Rezoning Transportation Analysis

Petition Number: 2023-094

Revision Log:

Date	Description
9-28-23	First Review (TM)
10-26-23	Second Review (TM)

RZ-1.0

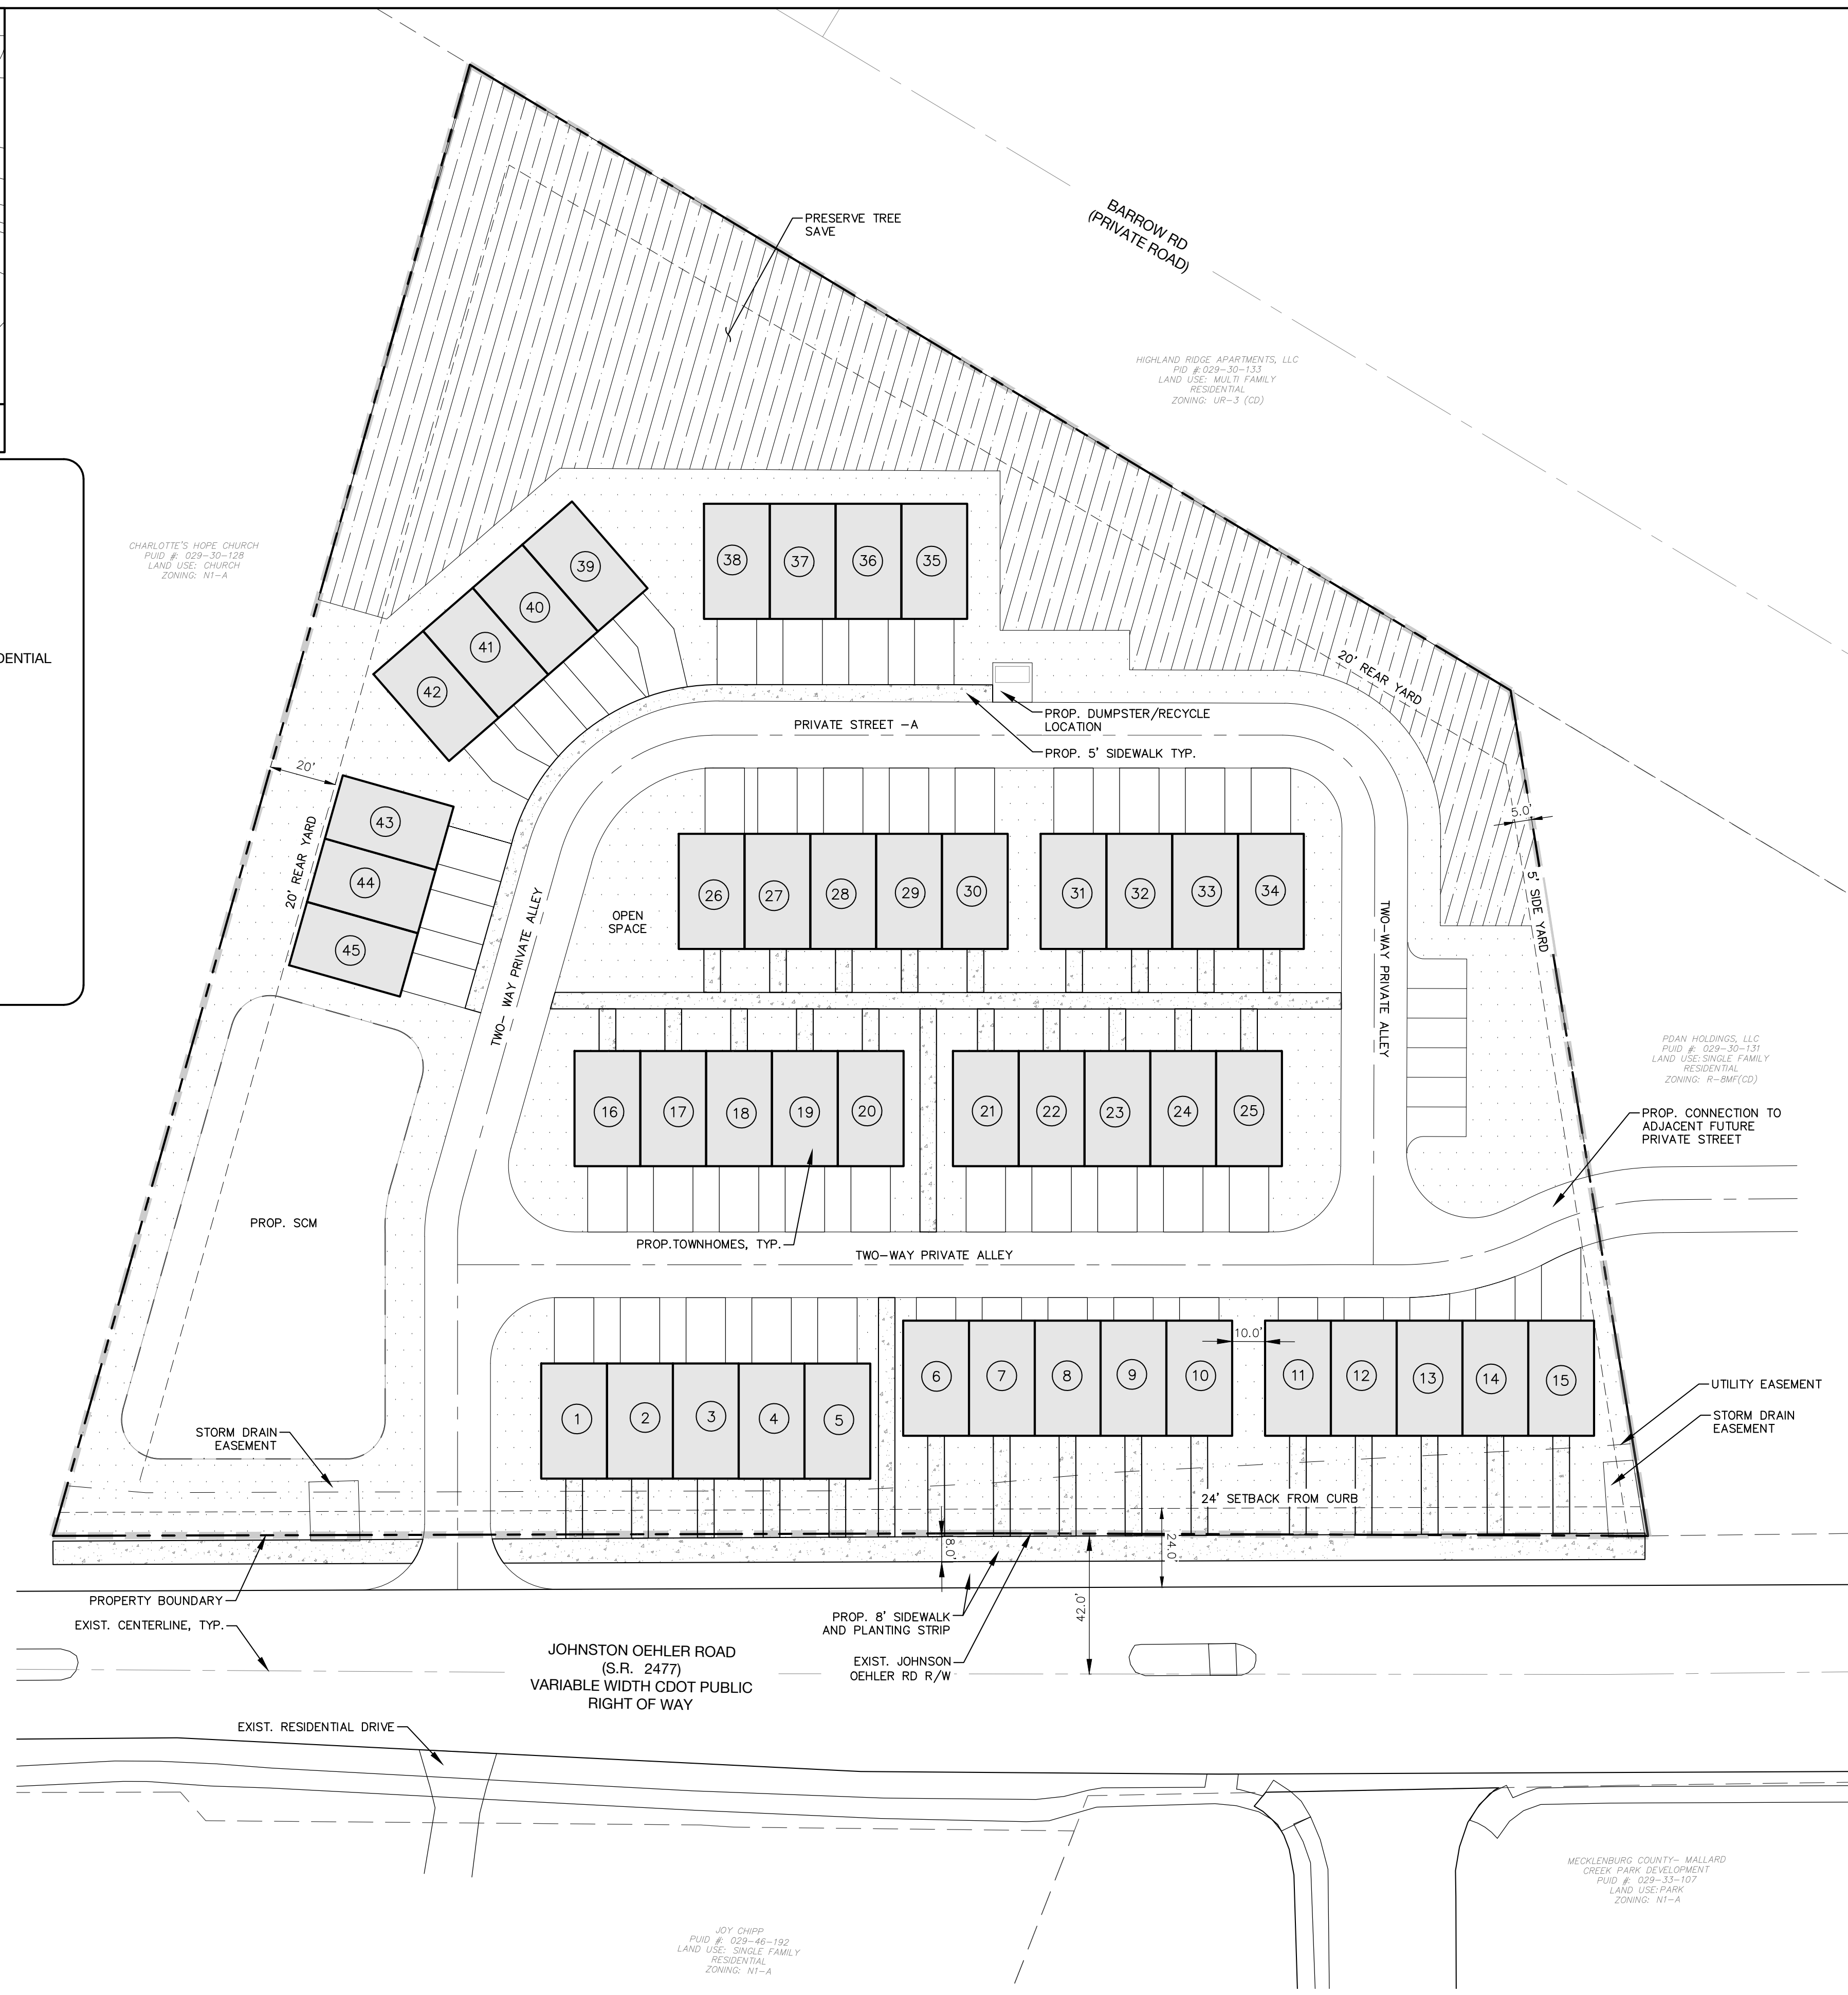
5. **Outstanding Comment from 9-28-23:** Revise site plan and conditional note(s) to commit to lining up driveway with driveway on the Southern side of the roadway.

Clarifying Comment from 10-26-23: Site access is to line up with the residential driveway on the southern side of the roadway. See image below.

6. **Outstanding CDOT REQUEST from 09-28-23:** Revise site plan and conditional note(s) to commit to installing a signalized pedestrian crossing at the existing pedestrian crossing location that would allow for connection to Mallard Creek High School.
7. ~~Add a conditional note specifying "the Petitioner shall dedicate and convey in fee simple all rights-of-way to the City before the site's first building certificate of occupancy is issued. CDOT requests rights-of-way set at 2' behind back of sidewalk where feasible."~~
8. ~~Add a conditional note specifying "All transportation improvements will be approved and constructed before the site's first building certificate of occupancy is issued."~~

9. **New Comment 10-26-23:** Remove conditional note referencing reverse angle parking

5. THE PETITIONER AGREES TO COORDINATE WITH CDOT ON ALL APPROPRIATE SIGNAGE RELATED TO THE PROPOSED REVERSE ANGLE PARKING DURING THE PERMITTING PROCESS.
